Case No.: 22-06-2510P
Community: City of Albuquerque, and
Bernalillo County, New Mexico
Community No.: 350002 and 350001

Identifier:	Juan Tabo Hills
Flooding Source:	Tijeras Arroyo
FIRM Panel(s) Affected:	35001C0366H and 35001C0367H

Summary of Additional Data Required to Support a Letter of Map Revision (LOMR)

PROJECT Twin Turbo Hills West
SUBJECT Section 3
BY _____ DATE _____
CHECKED _____ DATE _____
SHEET _____ OF _____

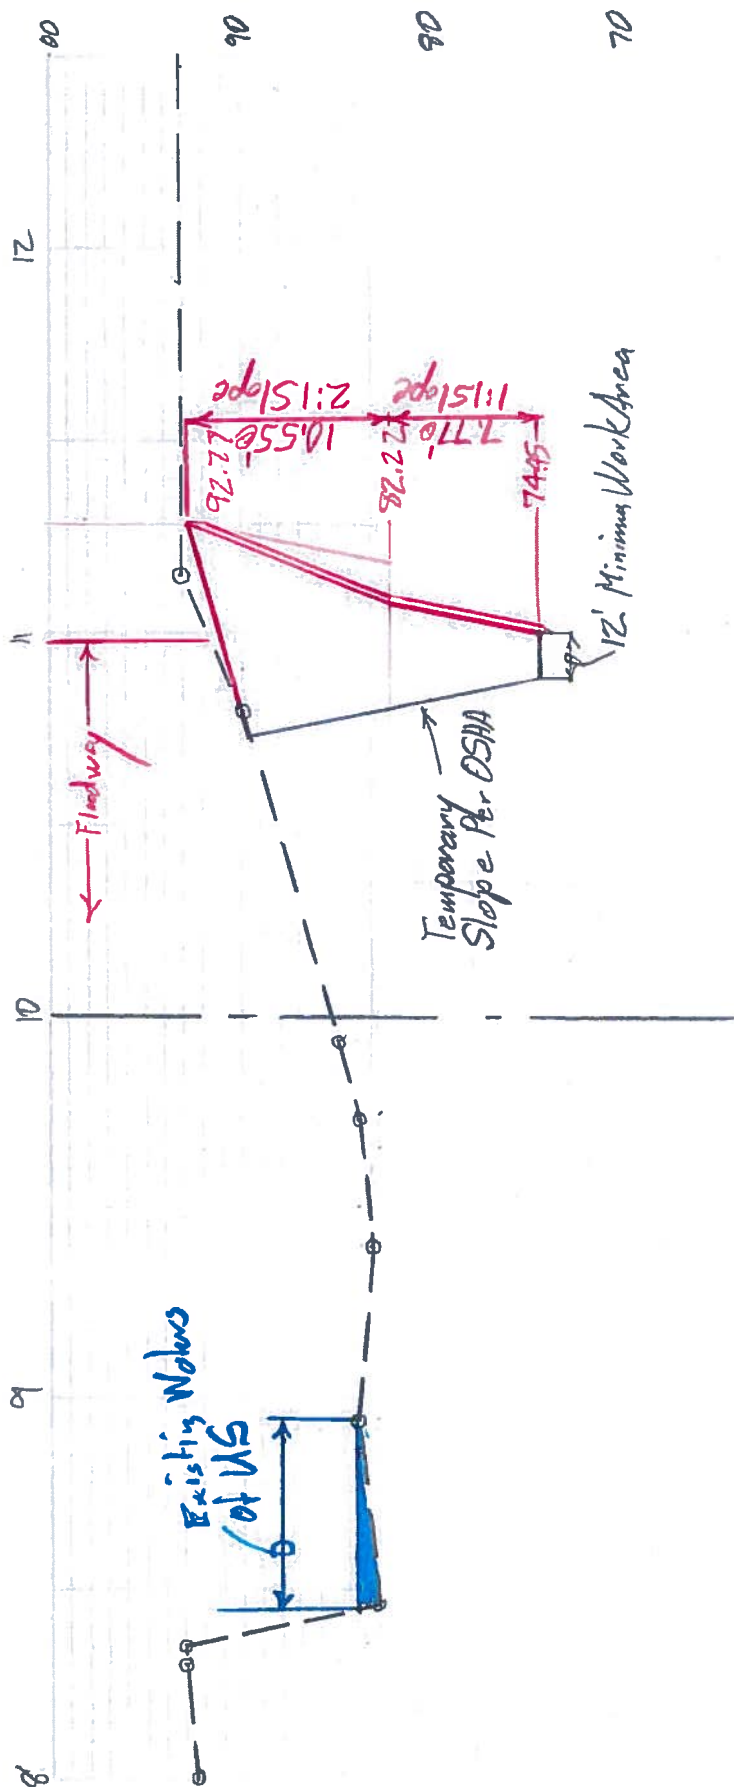
4. Our review revealed that the channel bank stations along the shotcrete bank protection at Cross Sections 3.5, 4, 5, 6, 8, and 10 are located at the bottom of the section along the left bank, but are at the top of the section at Cross Sections 3 and 15. Channel banks, and associated Manning's "n" values, should be consistent along the face of the bank protection. Please review these cross sections and either revise the channel bank stations to be consistently placed or provide an explanation for why these channel bank stations were chosen.
